NON-MATERIAL AMENDMENT STATEMENT

JANUARY 2020

SITE:	LAND ADJ LAKE BARN, MAYPOLE LANE, YAPTON, WEST SUSSEX, BN18 0DR
PROJECT:	ERECTION OF DETACHED SINGLE STOREY DWELLING HOUSE WITH VEHICULAR ACCESS FROM MAYPOLE LANE
CLIENT:	MR & MRS PAYNE
LPA REF:	Y/32/19/RES

Scale: 1:50 @ A2 BC/ BD
Project: MAY01
Drawn By: 310/ 05
Date: 20/12/'19
Revision: -

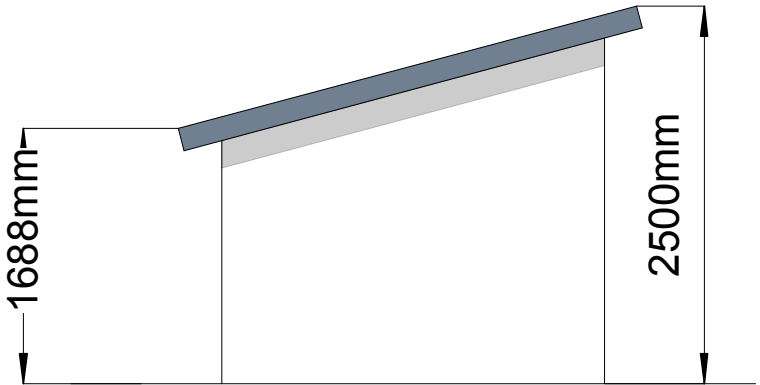
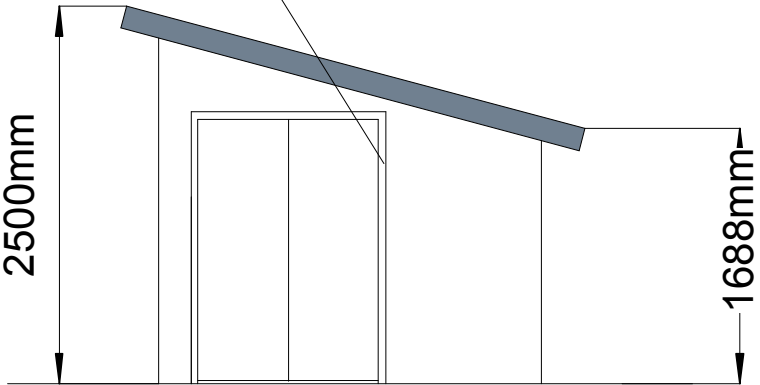
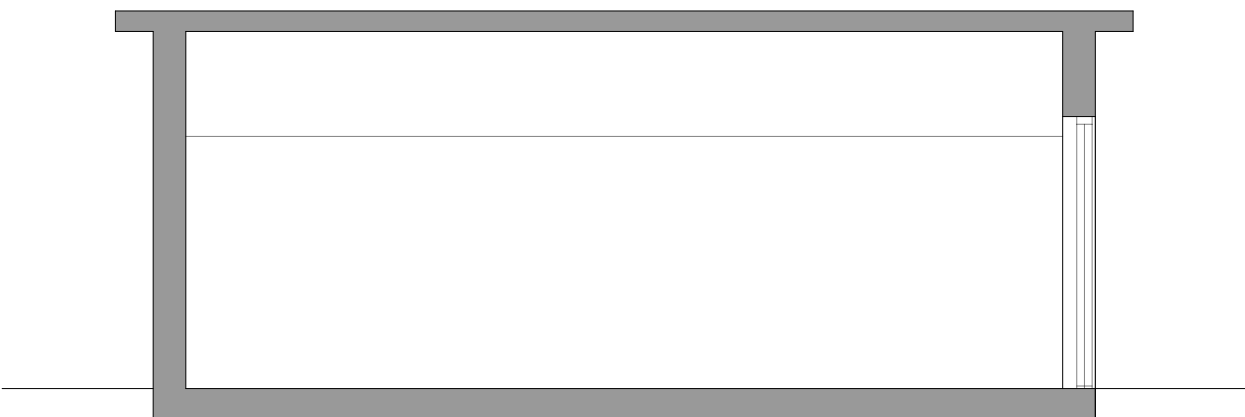
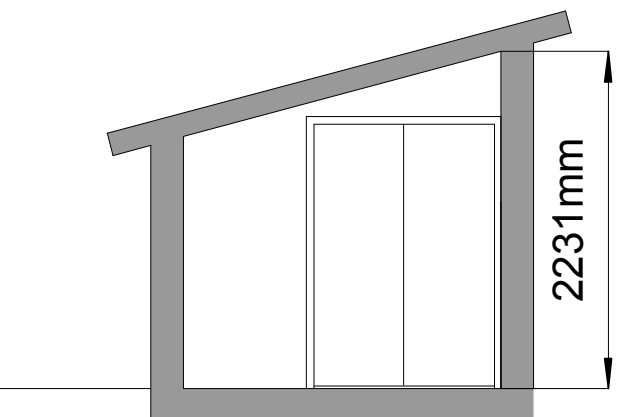
- (i) Insertion of bio-bubble and associated cabinet;
- (ii) Change of to the number of windows and their aperture size on the front elevation;
- (iii) Removal of a set of double doors on the rear elevation of the entrance hall;
- (iv) Removal of formerly proposed flue (south facing roof slope);
- (v) Changes to the doorway to the bike store.
